DEVELOPMENT REVIEW BOARD
SUPPLEMENTAL SUBMITTAL

PROJECT NO. PR-2020-004747

Application No. SI-2021-00484

DESCRIPTION: Revised site plan & detail sheet, revised building elevations with response letter, revised landscape plan,

A2.0A
 SHEET: OF: X

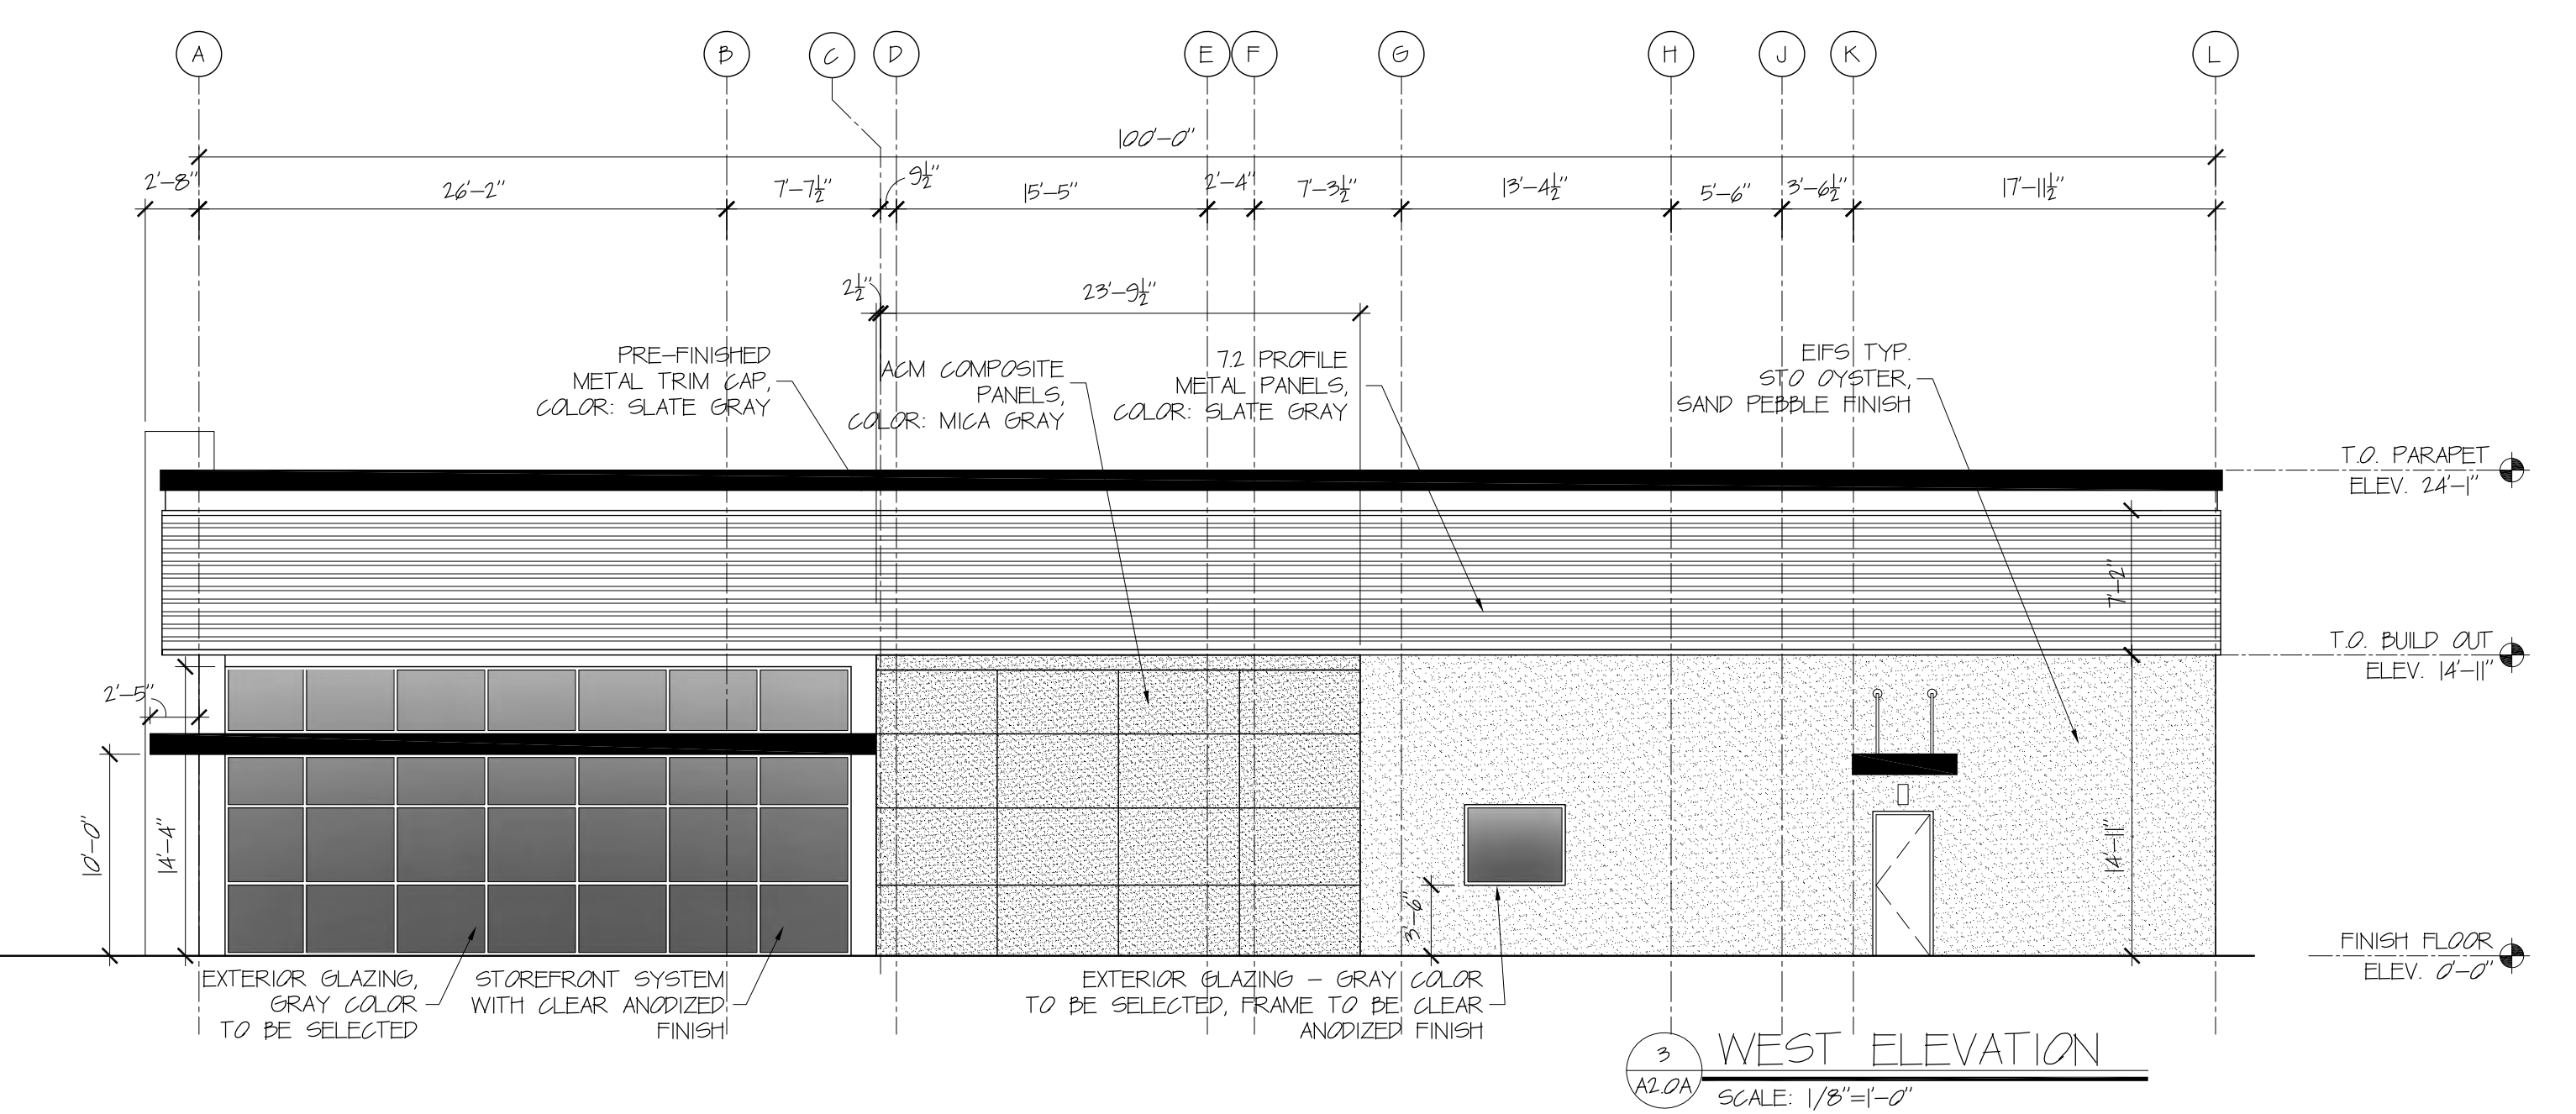
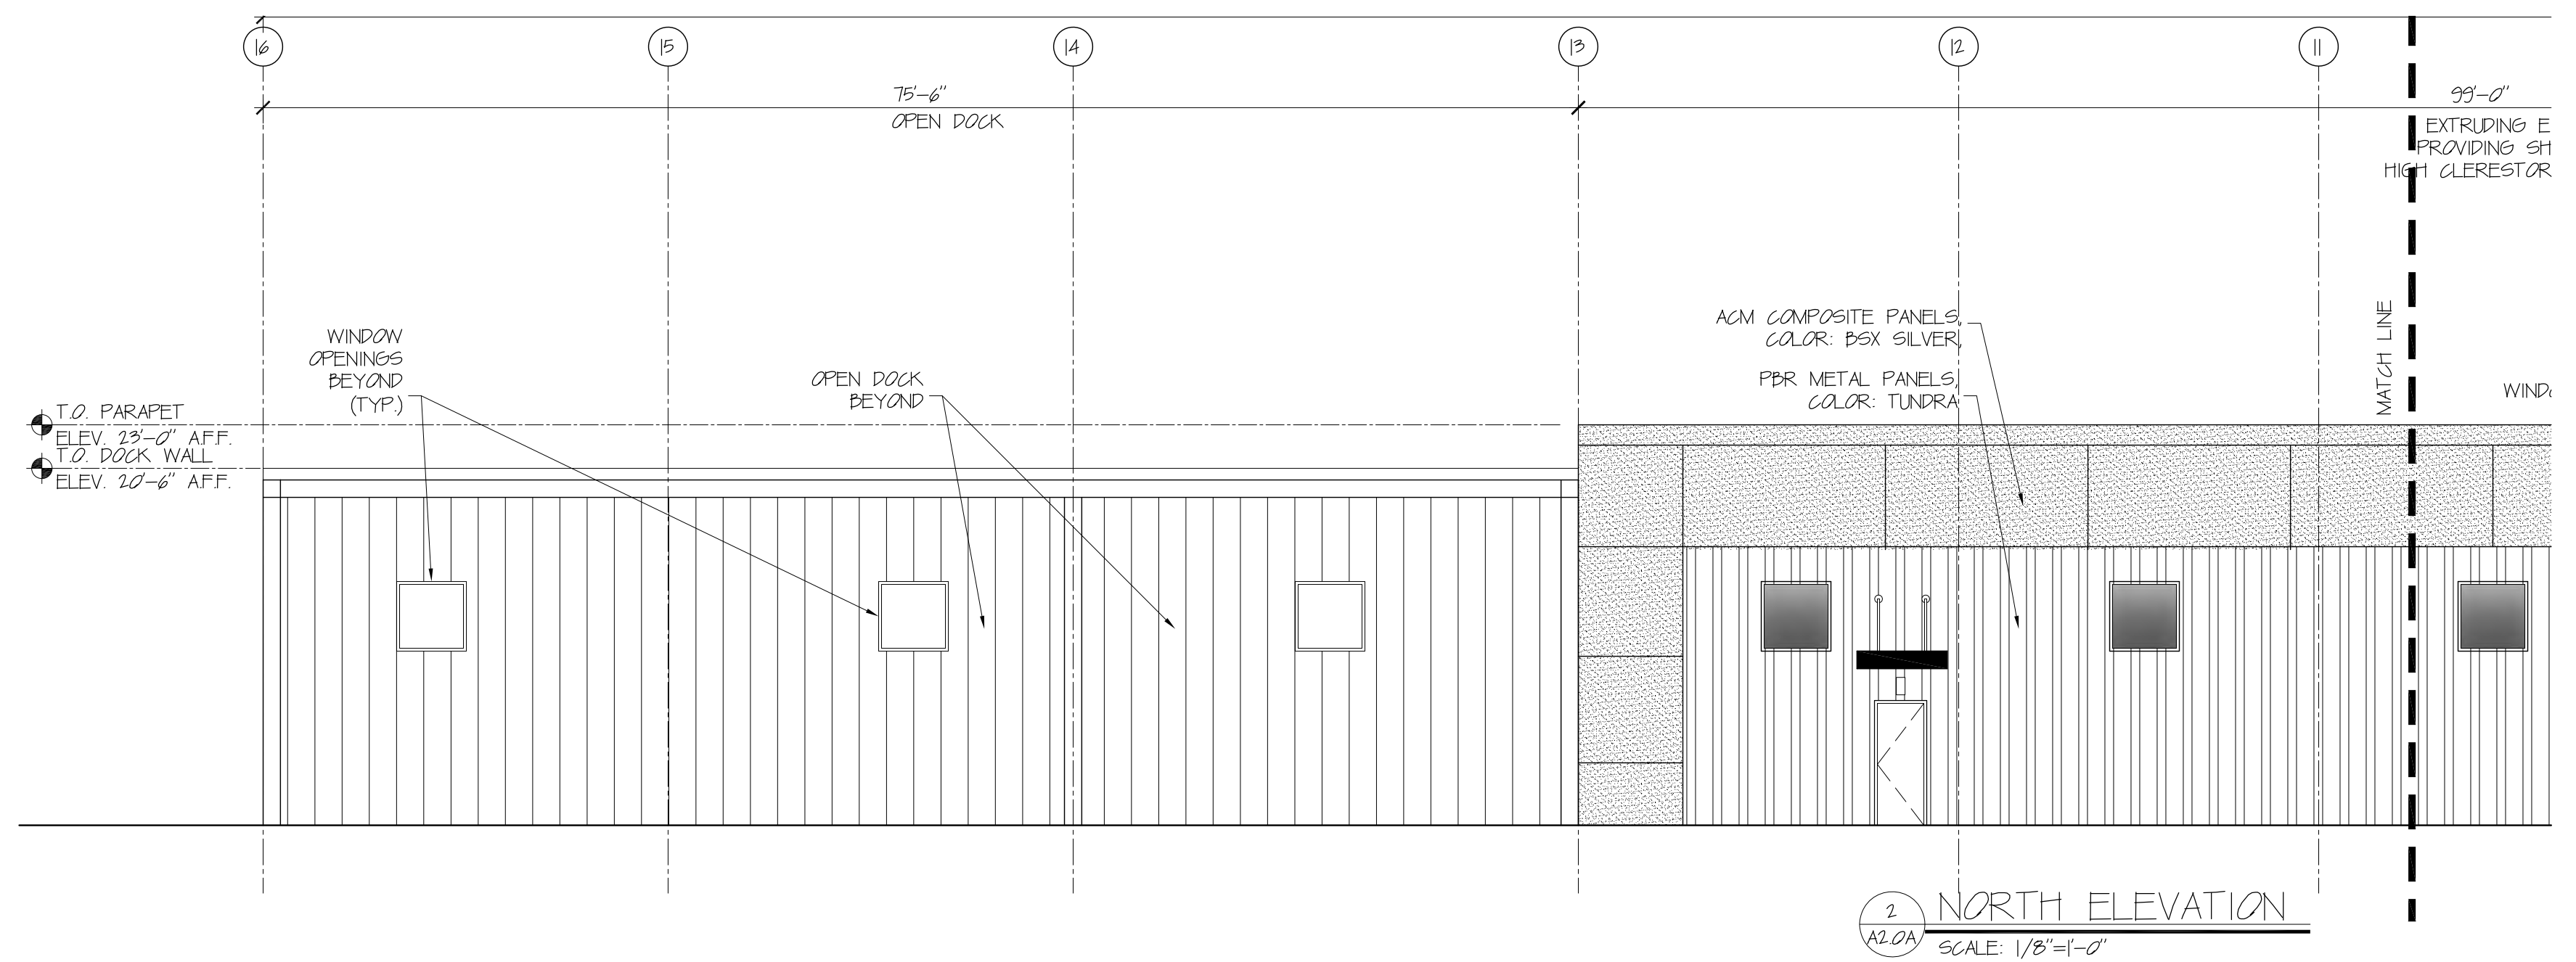
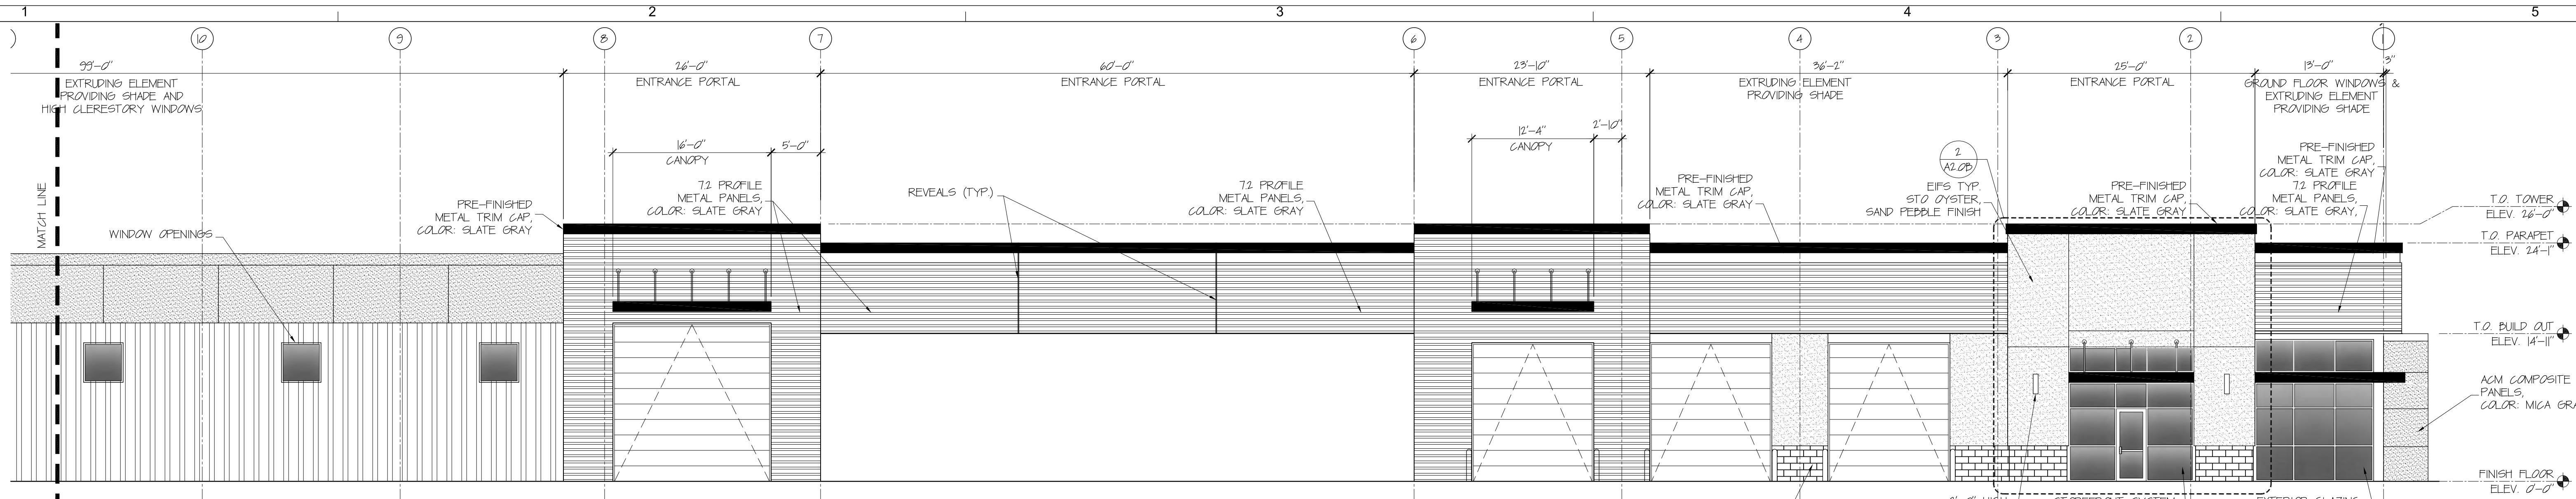
Elevation Review Comments:

The elevation needs to meet the following requirements:

1. Façades shall be designed to provide a sense of human scale at ground level by providing a clear architectural distinction between ground floor levels and all additional levels.

2. Each street-facing façade shall incorporate at least 2 of the following features along at least 30 percent of the length of the façade, distributed along the façade so that at least 1 of the incorporated features occurs every 40 feet.

3. Each street facing façade longer than 100 feet shall incorporate at least 1 of the following additional features.

Response for requirement #2:

The North façade:

incorporates ground floor windows, primary entrance, high clerestory windows, portals, canopies and extruded wall elements providing shade. The total length of the façade is 358 feet and 9 inches. 30 Percent of the façade is 108 feet.

2d) Entrance portals, canopies and extruding elements providing shade have been placed along a total of 310 feet along the façade length. See elevation. Arcades, trellises and awnings not provided.

The South façade:

incorporates extruding elements, an entrance portal and high clerestory windows. The total length of the façade is 358 feet and 9 inches. 30 Percent of the façade is 108 feet.

2d) Entrance portals, canopies and extruding elements providing shade have been placed along a total of 310 feet along length of façade.

The North façade:

3a) Wall plane projections or recesses of at least 1 foot in depth at least every 100 feet of façade length provided.

3e) Change in parapet height every 100 feet of façade length provided.

See North elevation for change in parapet height every 100 feet.

3e) Change in parapet height every 100 feet of façade length provided.

See South elevations for change in parapet height every 100 feet.
